Re: State Significant Development Application – SSD9813 – Gosford Alive, Response to Response

ATTACHMENT B: CCLHD Public Health Unit, response to Proponent’s Response to Submissions (RTS), SSD 9813 (Gosford Alive Project), 136-148 Donnison St Gosford

SOLAR ACCESS TO KEY PUBLIC SPACE (DCP):

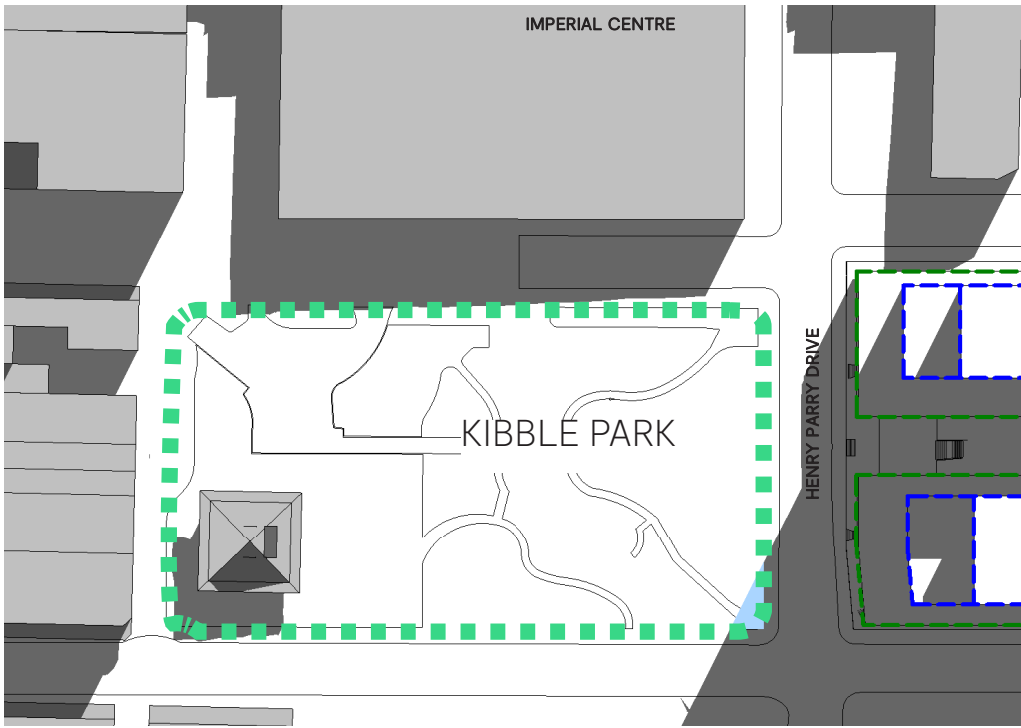
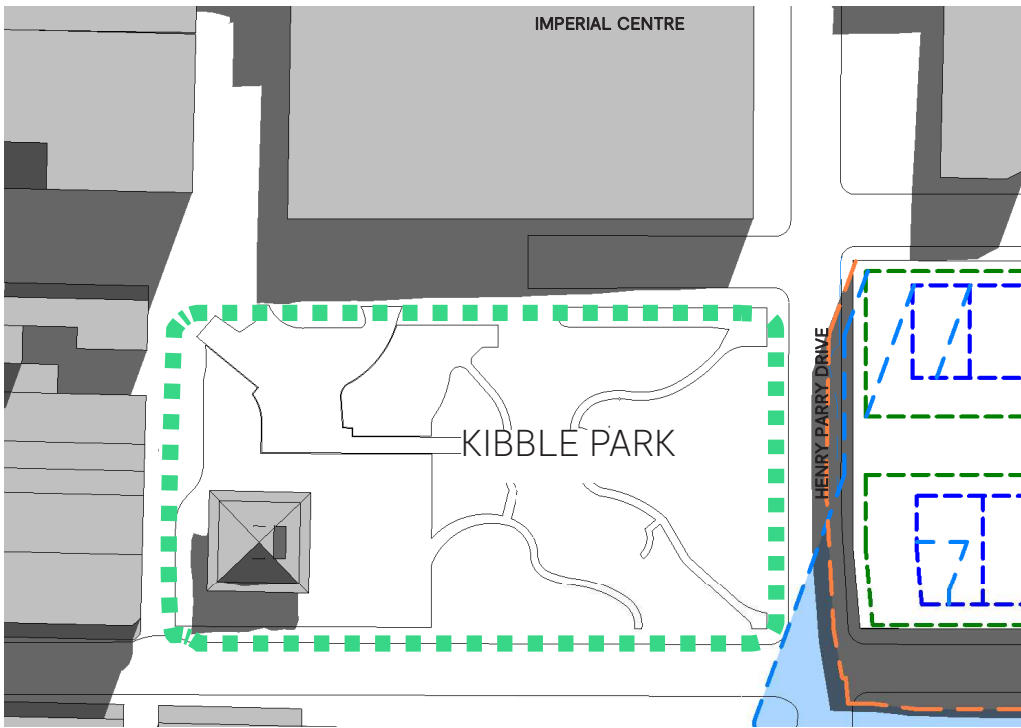
We note recent design alterations. The proposed building heights and floor space ratios still exceed the current zoning controls. We reiterate that overshadowing and impacts on solar access should be strictly minimised with consent conditions to assure this.
